Your Ref: OWPC15420
Our Ref: EP/106/17/PL 20-07-2017
Please ask for:
Andrew Wood

Loft conversion of existing building.
The Dolphins (east) South Strand EAST PRESTON

Thank you for your internet representation made on 31st August 2017 which has been recorded as '**an objection**' with the comments as follows:

PROPOSED ROOF PLAN

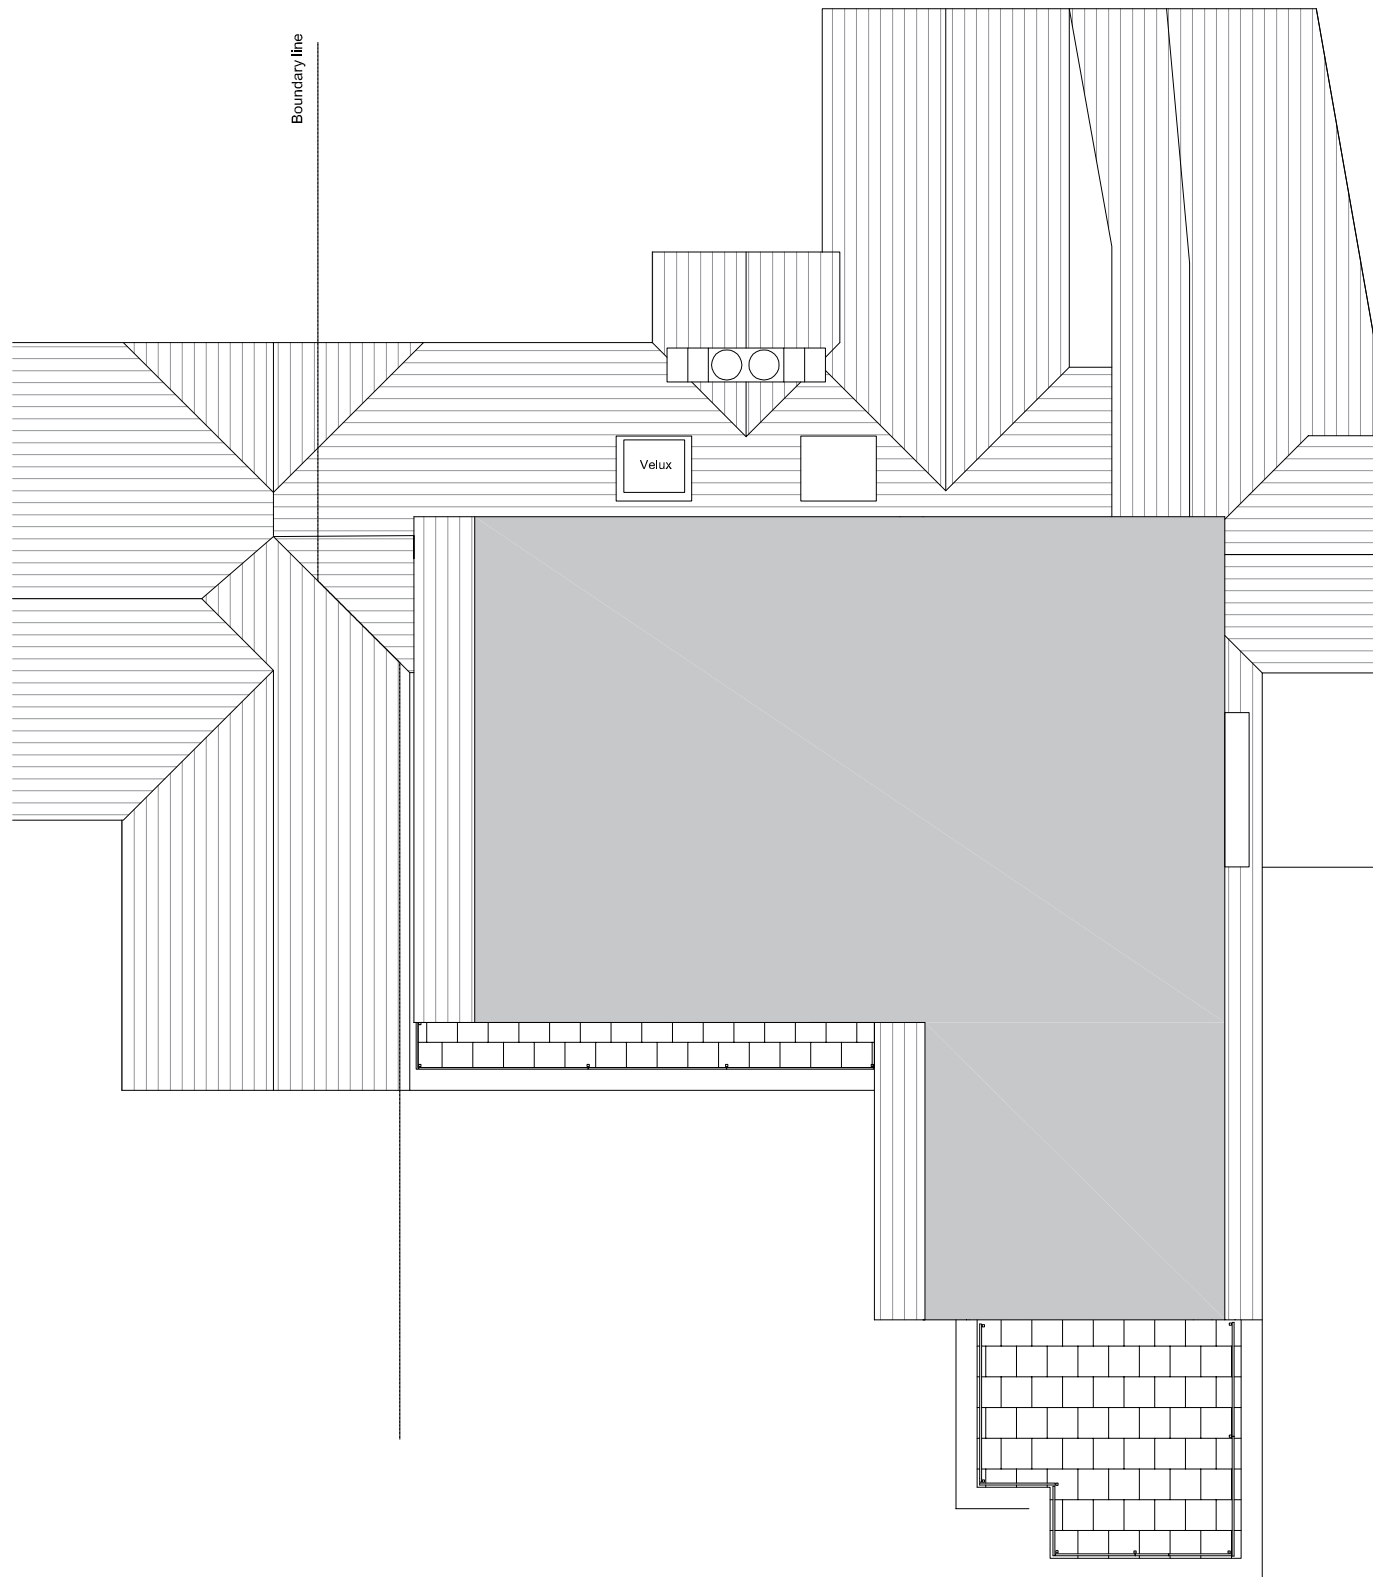
The western section has a single dormer with a door leading to a balcony. This application proposes that the whole length of the eastern section at first floor level would comprise tall windows leading onto a balcony, which would have a glazed balustrade. It would therefore form a complete contrast to the western section, and would be out of character with the design of the existing house.

PROPOSED SOUTH / REAR SIDE ELEVATION

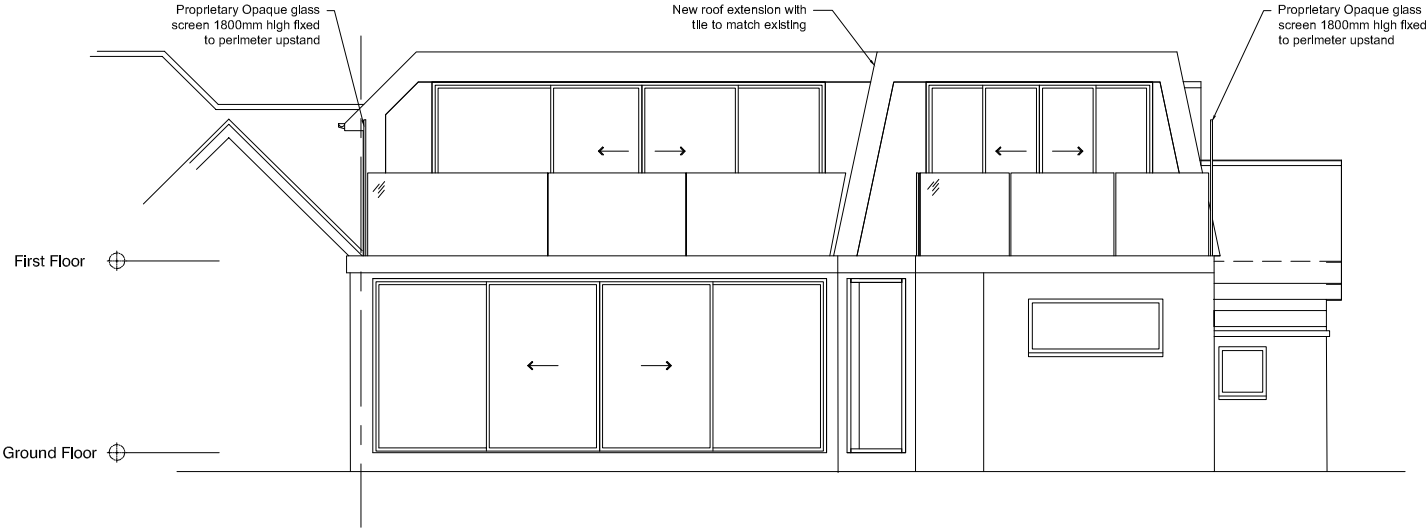
The main defect of this application is that it does not treat The Dolphins as a single building. It proposes alterations to the eastern section of the building which ensure that the two parts of the building would be in clashing styles. They should harmonise.

This new balcony and windows are nominally at the rear of the building but are at the side visible to the public, from the beach. The northern side of the building is hidden from the road by newer houses.
